## **Development Facilitation Team (DFT) – Review Comments**

**DRB Project No: PR-2020-003484 Date: 10/25/2023 Agenda Item: #3 Zone Atlas Page: E-10**

**Application For: SD-2023-00048 – PRELIMINARY PLAT (DHO)**

**Project Name:** 6341 Mojave St NW

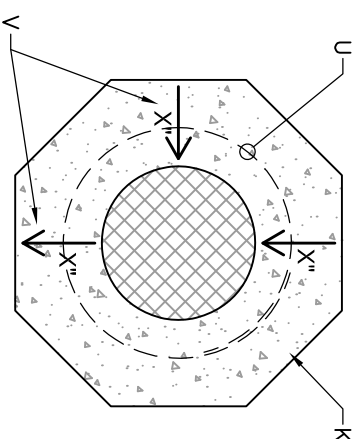
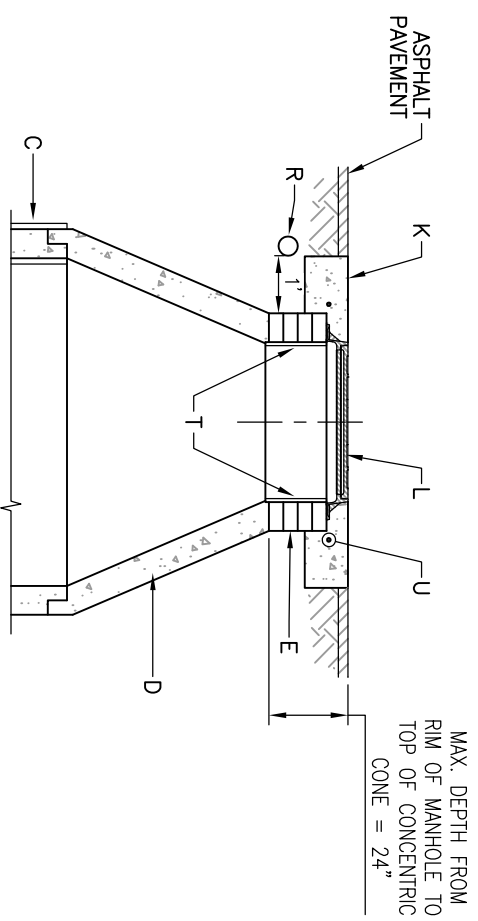
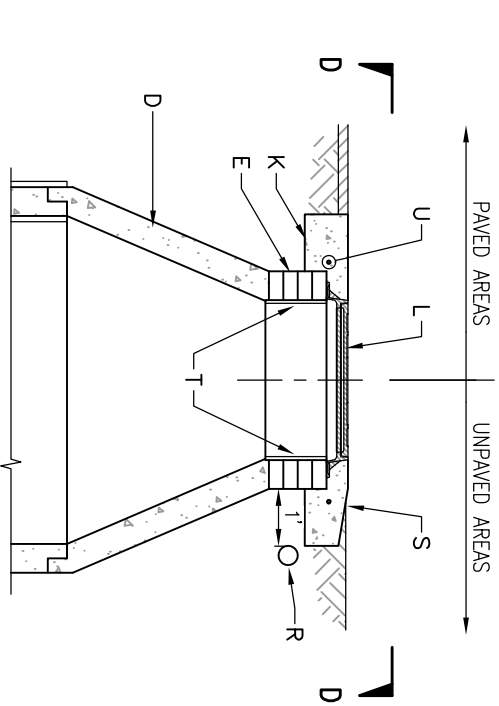
Updated 10.25.23 Applicant submitted a plan view of the sewer connection to the existing manhole. A cross section of the connection from both the north-south and east-west planes is likely necessary to clearly understand the potential disturbance. No written description was provided. It does not appear that the applicant met the National Park Service request for information nor other items in this Planning Comment memo. Planning comments remain unaddressed.

Updated 10.23.25 This processing of the sewer connection as an extraordinary facility is dependent upon the applicant's ability to connect the sewer line to the existing manhole with minimal disturbance. This has not been adequately demonstrated to date.

PRELIMINARY PLAT FOR  
**MOJAVE RIDGE SUBDIVISION**  
 (A REPLAT OF LOTS 2 & 3, BLOCK 12,  
 UNIT 3, VOLCANO CLIFFS SUBDIVISION)  
 WITHIN  
 SECTION 27,  
 TOWNSHIP 11 NORTH, RANGE 2 EAST, N.M.P.M.  
 CITY OF ALBUQUERQUE  
 BERNALILLO COUNTY, NEW MEXICO  
 JANUARY, 2023

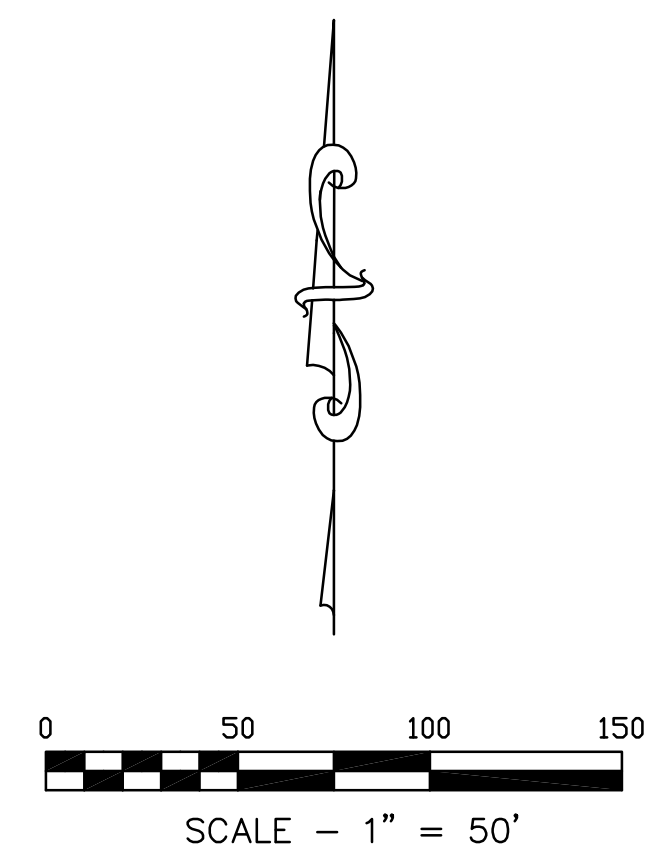
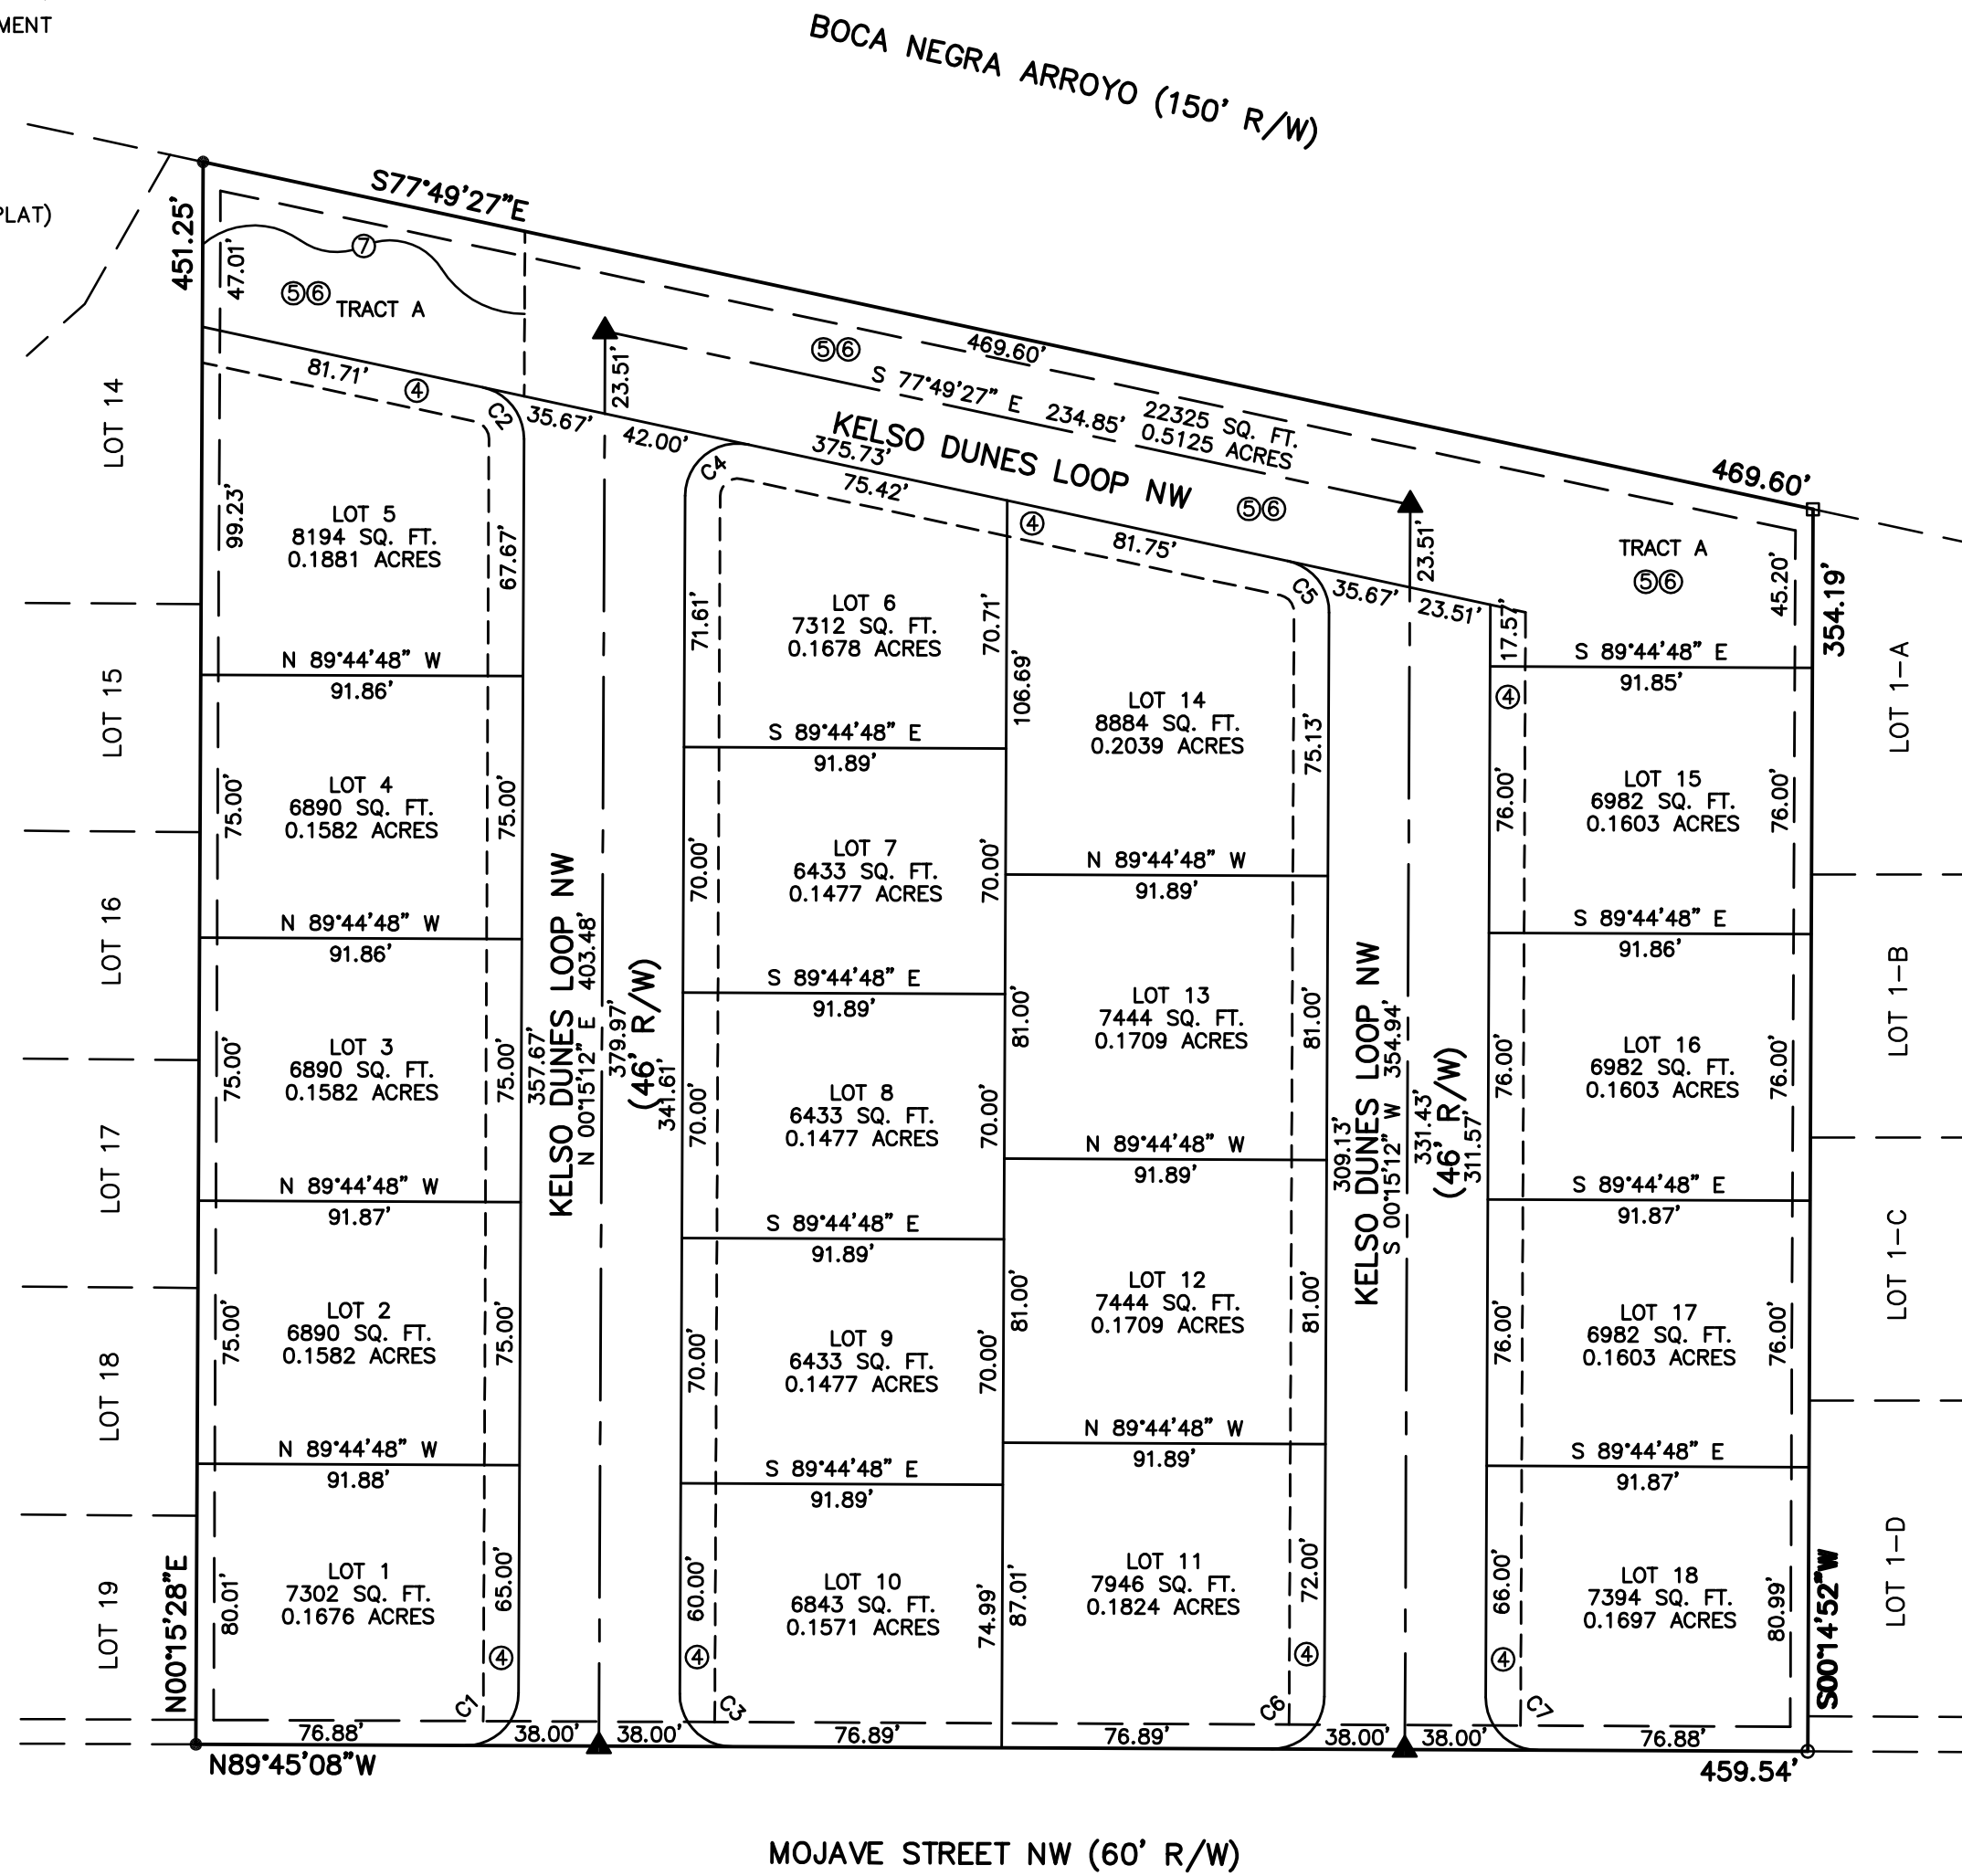
1. Since the IDO indicates the 45 foot required buffer required as per IDO 5-2(J)(2)(a)(1) must be approved by the Open Space Superintendent, Code Enforcement would like to confirm Parks is in agreement with the plat proposed showing Tract A will serve as that buffer. The required landscape buffer area should be clearly marked and/or noted on the plat, as discussed in prior Hearings (on 5/10 and 6/28).
2. CE has no further comments or objections.

- **Updated 10.23.23** 5-2 (J)(2)(a) Lot 5 is abutting the Boca Negra arroyo. **Applicant has been told multiple times that the Open Space buffer needs to be a separate tract with a note to the plat indicating that the 45 feet buffer abutting the Petroglyph National Monument must have plant approval and location per the Open Space Superintendent.**
